Application for a Non-Material Amendment Following a Grant of Planning Permission

Land to the West of Church Lane and South of Horsemere Green Lane

CM/48/21/RES

To alter reference to certain detailed landscape plans under condition 1

DRAWING TITLE
Detailed Planting Plan
17 of 30

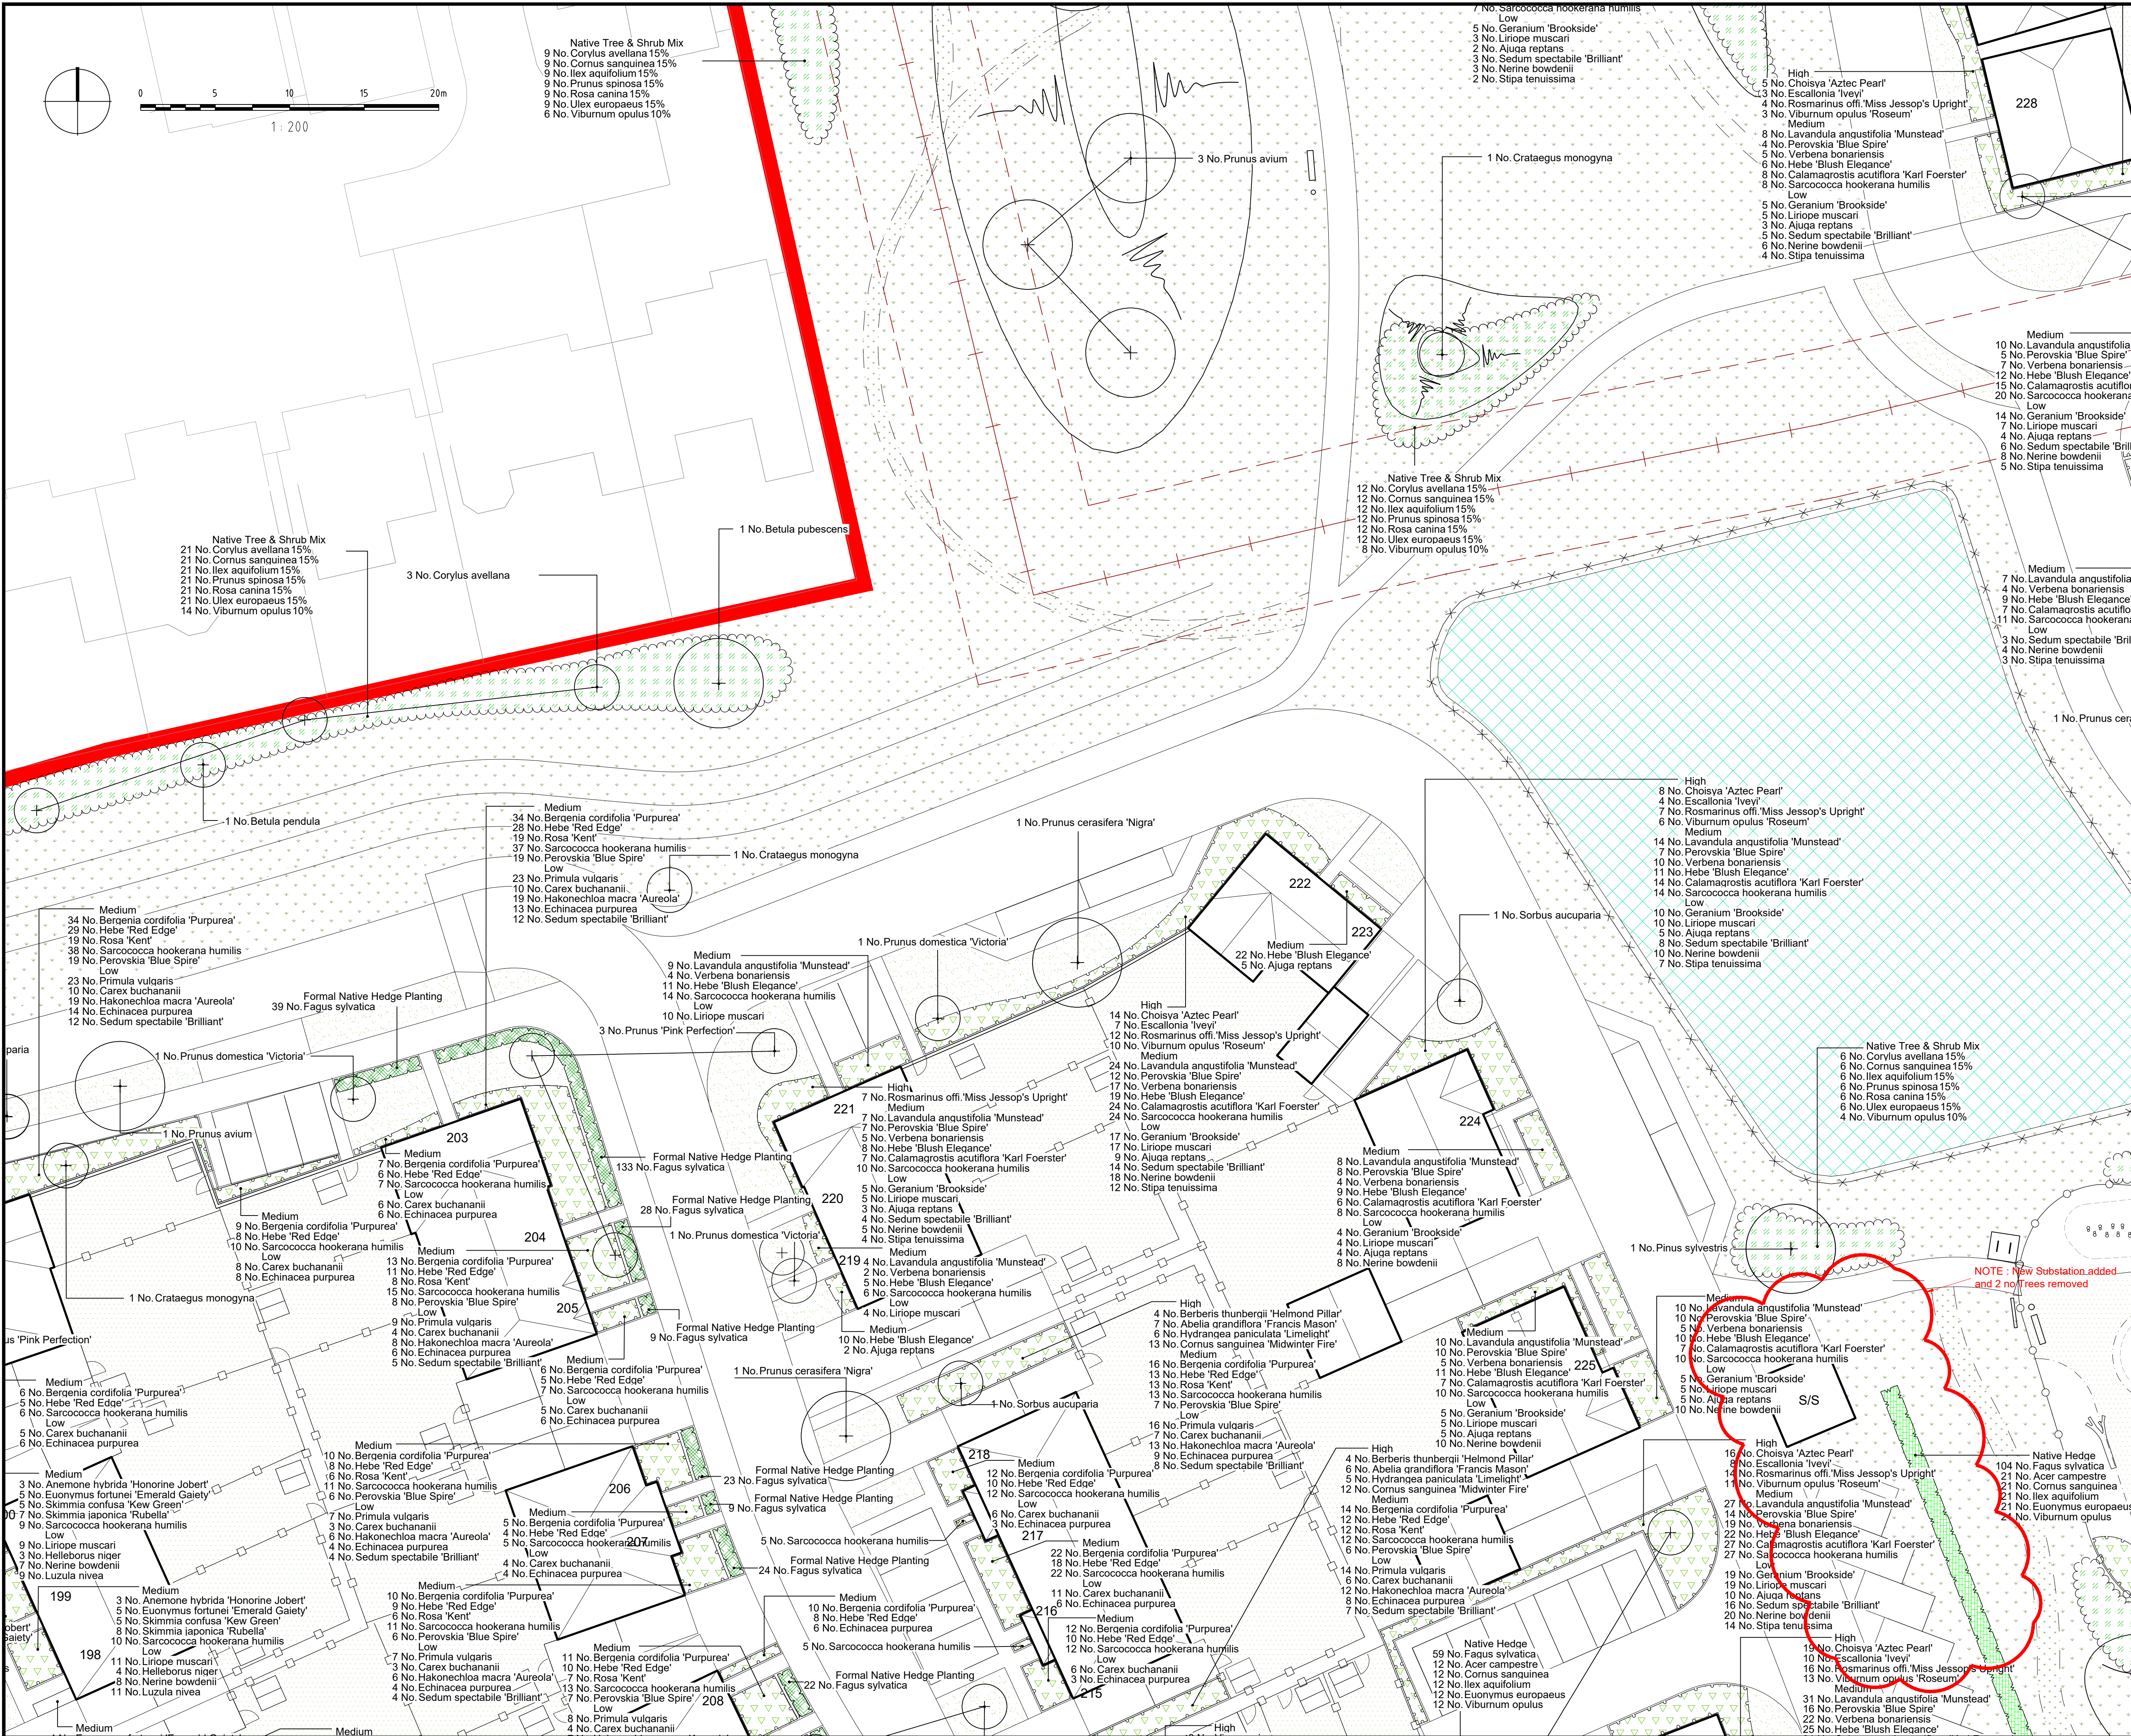
A sub-station is required to facilitate the provision of electricity to the residential units and so the landscaping has been amended to reflect its siting.

Concern has been raised over the tree species approved to be planted as part of the landscape scheme - specifically along the boundary to the North that is shared with existing properties - as their roots will eventually have a negative affect on the ground conditions and footings of the existing properties and the large scale of the trees will impact the daylight that the existing residents currently benefit from. The trees have therefore been replaced with smaller species that will have far less of an impact on the ground conditions (and cause less shading) but at the same time, provide adequate screening of the development.

DD406L12E Detailed Planting Plan 1 of 30
DD406L14E Detailed Planting Plan 3 of 30
DD406L18E Detailed Planting Plan 7 of 30
DD406L22E Detailed Planting Plan 11 of 30
DD406L28F Detailed Planting Plan 17 of 30
DD406L29E Detailed Planting Plan 18 of 30
DD406L34F Detailed Planting Plan 23 of 30
